OFFICE OF THE CITY ENGINEER
BUILDING PLANS
DRAINAGE REVIEW

Disapproved 4-8-81

SITE PLAN - GRADING
1" = 10'

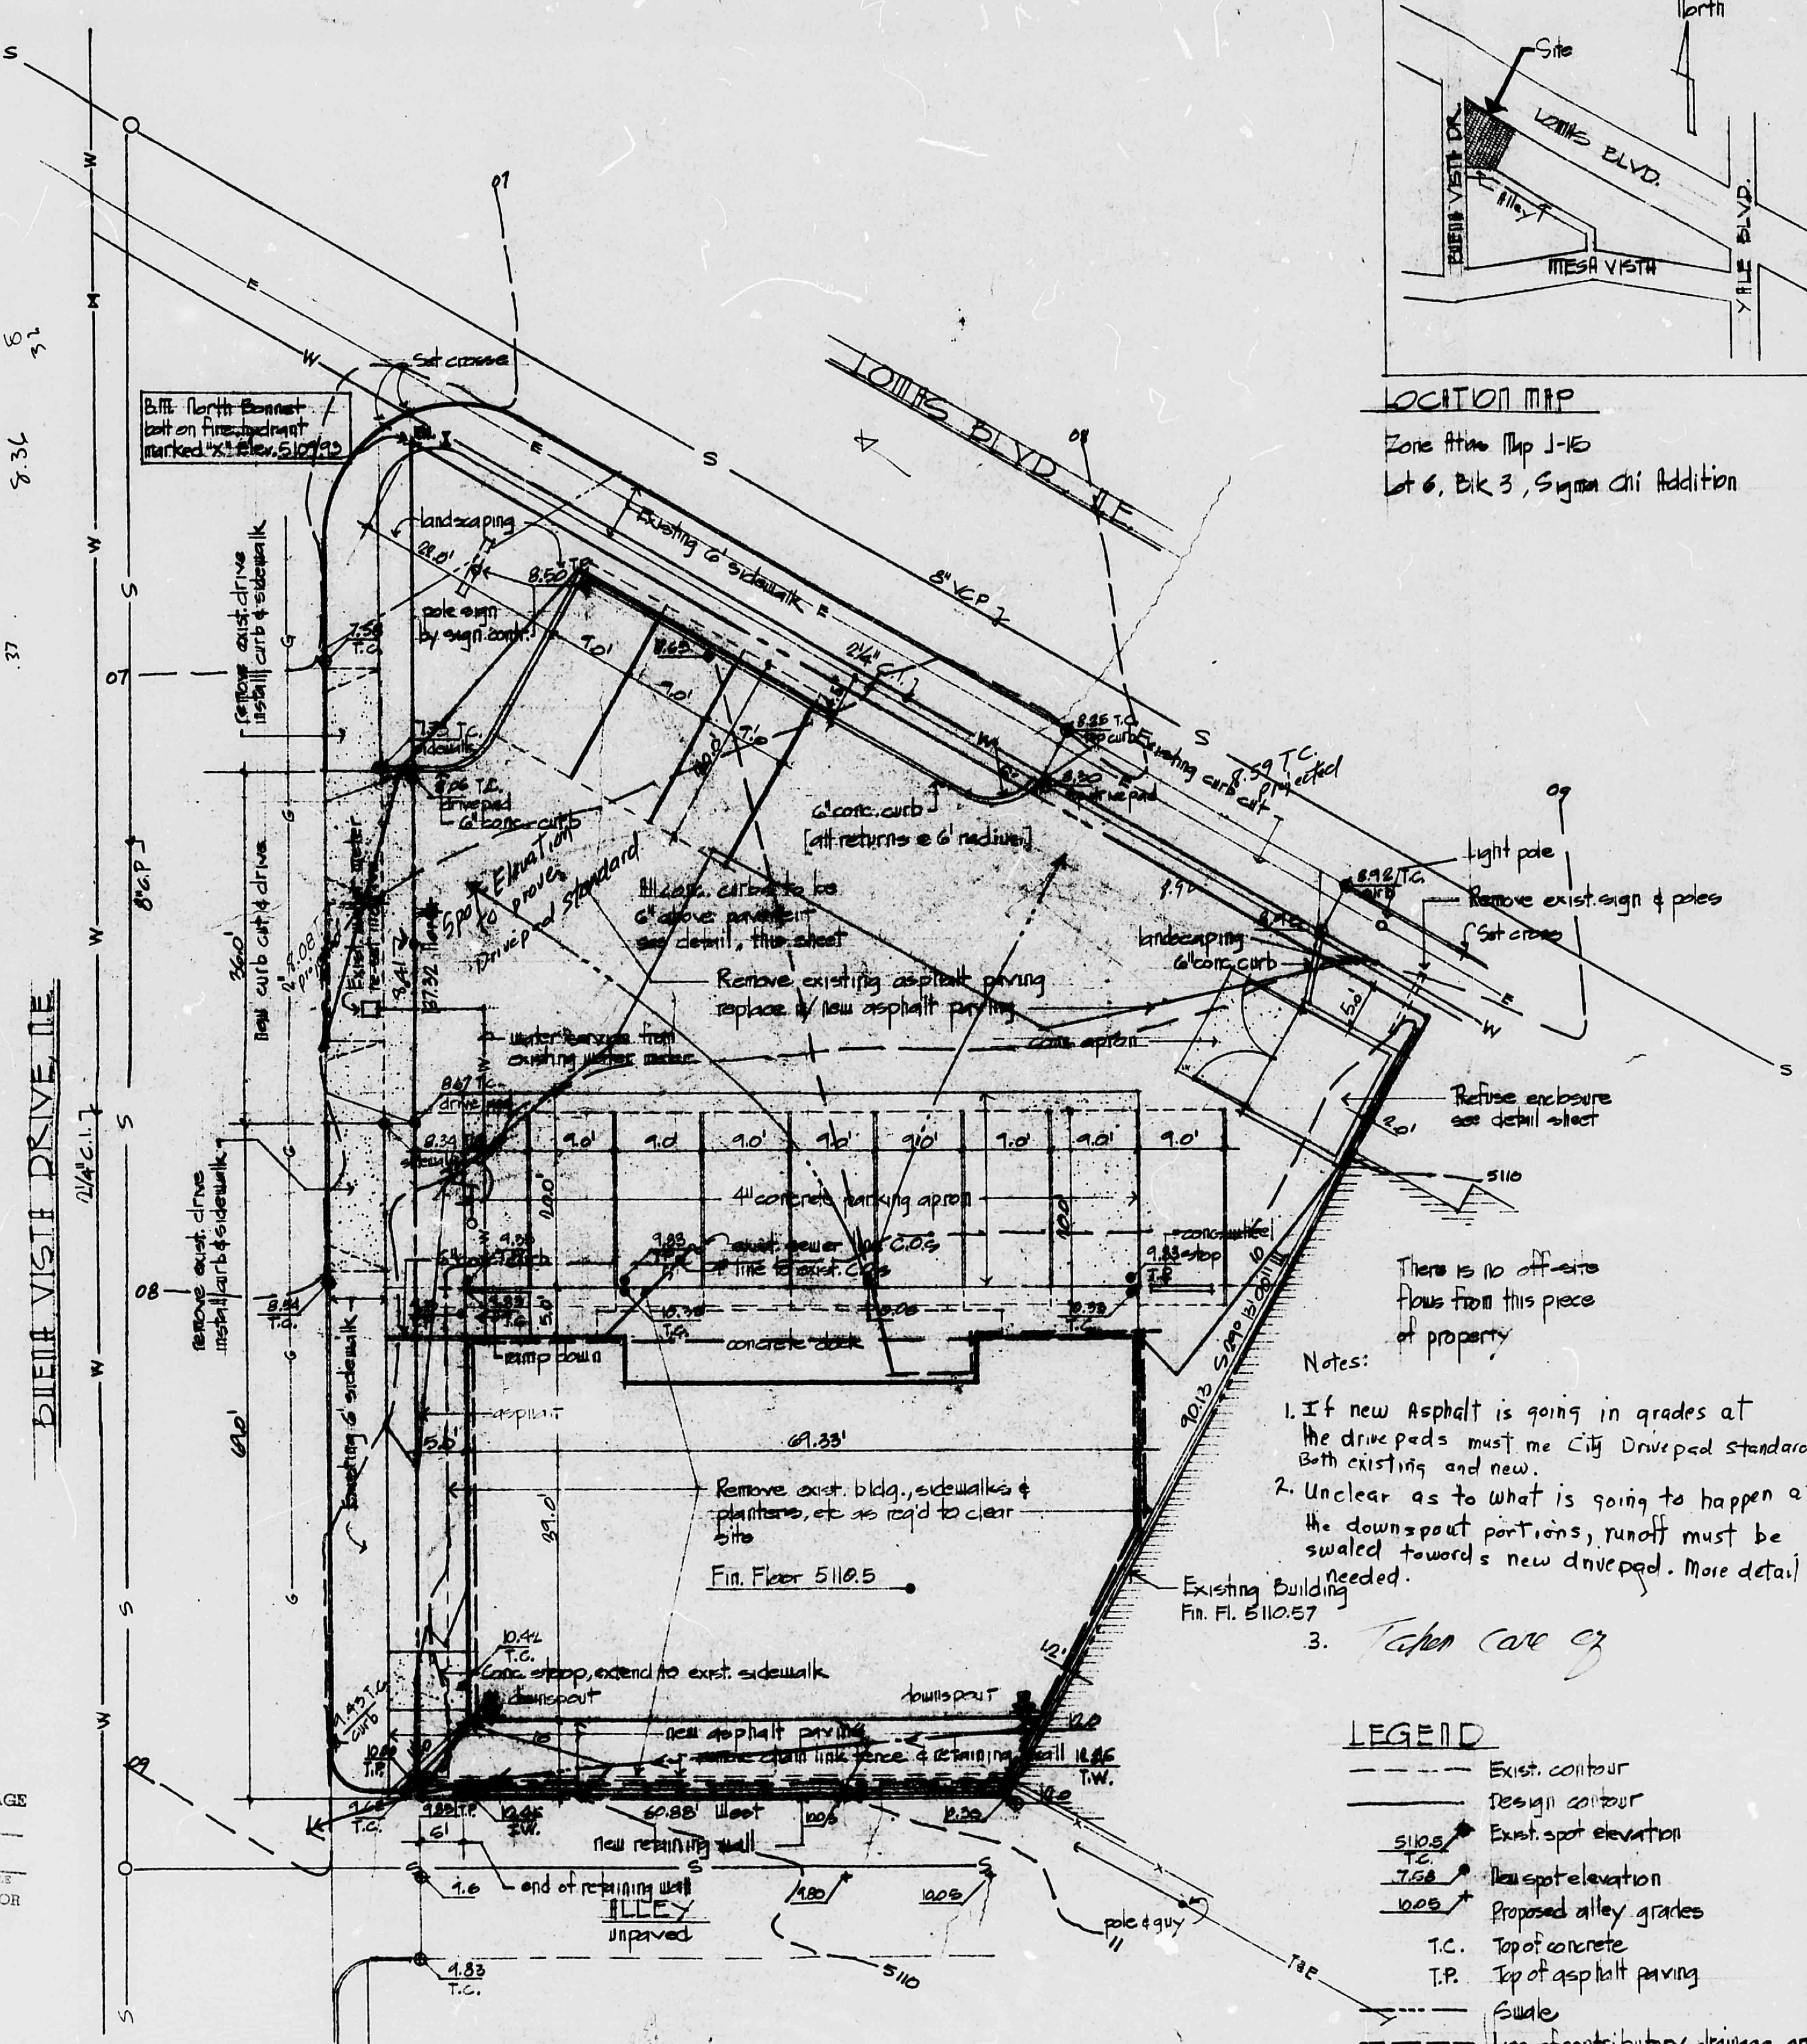
- (3) Proposed contours at one foot intervals and proposed spot elevations at key points.

- (4) Finish building floor elevation (s).
 - (5) Notes defining asphalt, sidewalks, planting areas, ponding areas, property line, and any other areas whose definition would increase clarity.
 - ✓(6) Proposed alley grades, if property abuts a dedicated unpaved alley. These grades are available, at no charge, from the City Engineer's office. An advance request will expedite your project.
 - (7) A description of the bench mark.
 - (8) Ground Elevation on the site based on mean sea level datum as established by the U.S. Coast and Geodetic Survey (North American Datum 1929).
- (B) A DRAINAGE PLAN SHOWING:

- ✓(D) A discussion of offsite flows must be included. If the contour maps disagree with the designers opinion of offsite flows, further information will be required.
- ✓(E) A discussion of any other local conditions that effect site drainage should be included.
- (F) Details of ponds, curbcuts, water blocks, and any other significant drainage structures must be included.
- (G) The professional who designs the drainage scheme must affix his/her stamp to the drainage plan.
- ✓(H) A copy of the drainage plan must also be included with the construction plans for our drainage files.
- (I) Construction in the public right of way requires approval, prior to construction, from the City Engineers office.
- (J) Indicate all easements on site or adjacent to the site with the following information: Location, width, and purpose.
- H) Show compliance with drievpad standard
